## KITTITAS COUNTY COMMUNITY DEVELOPMENT SERVICES

August 11, 2020

### **RE: Whitman Boundary Line Adjustment (BL-20-00018) – Transmittal of Comments and Request for Additional Information**

Site Plan

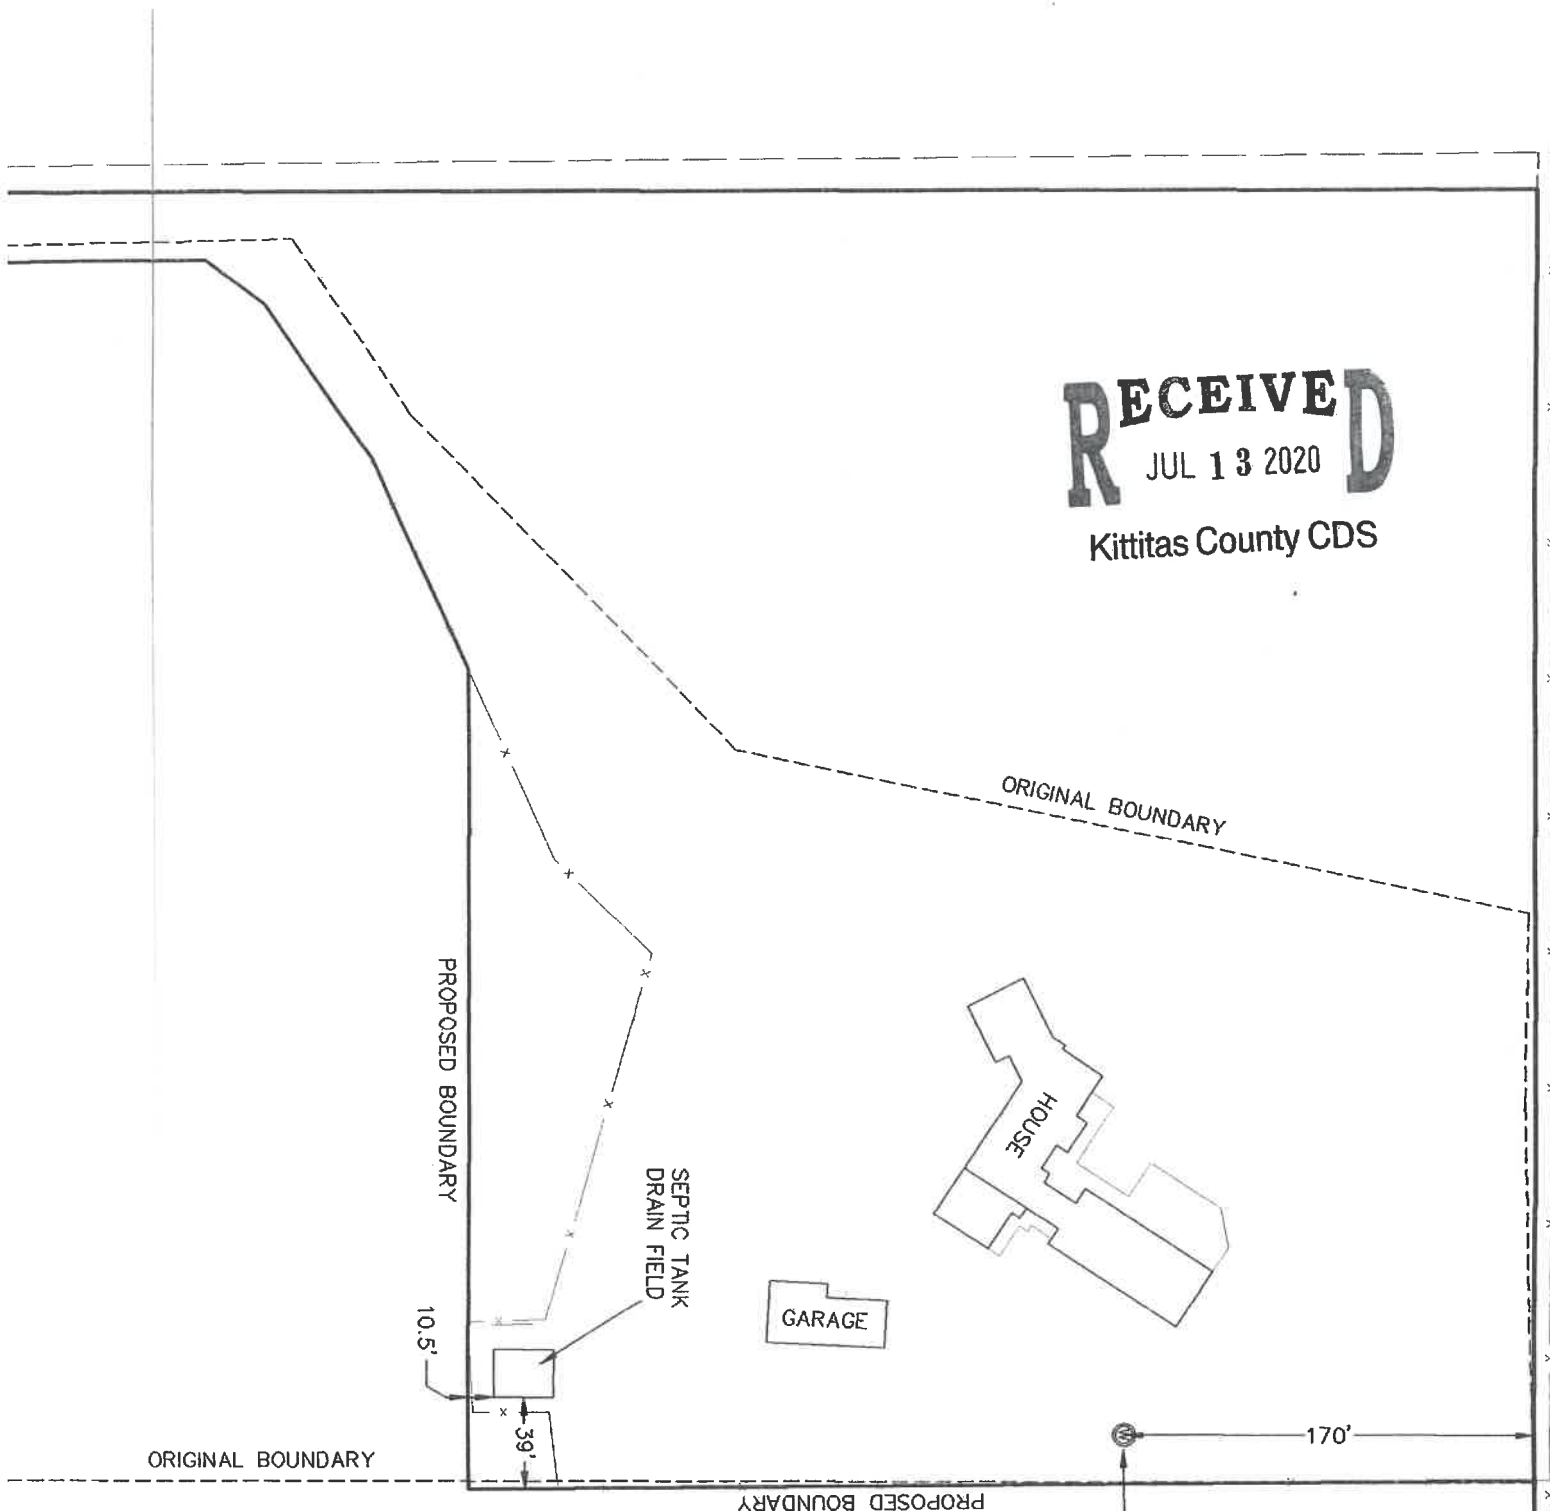
- An updated site plan depicting property line setback requirements consistent with Kittitas County Code 13.20.040 as described in Public Health comments, and
- An updated project narrative addressing Public Health's concerns.
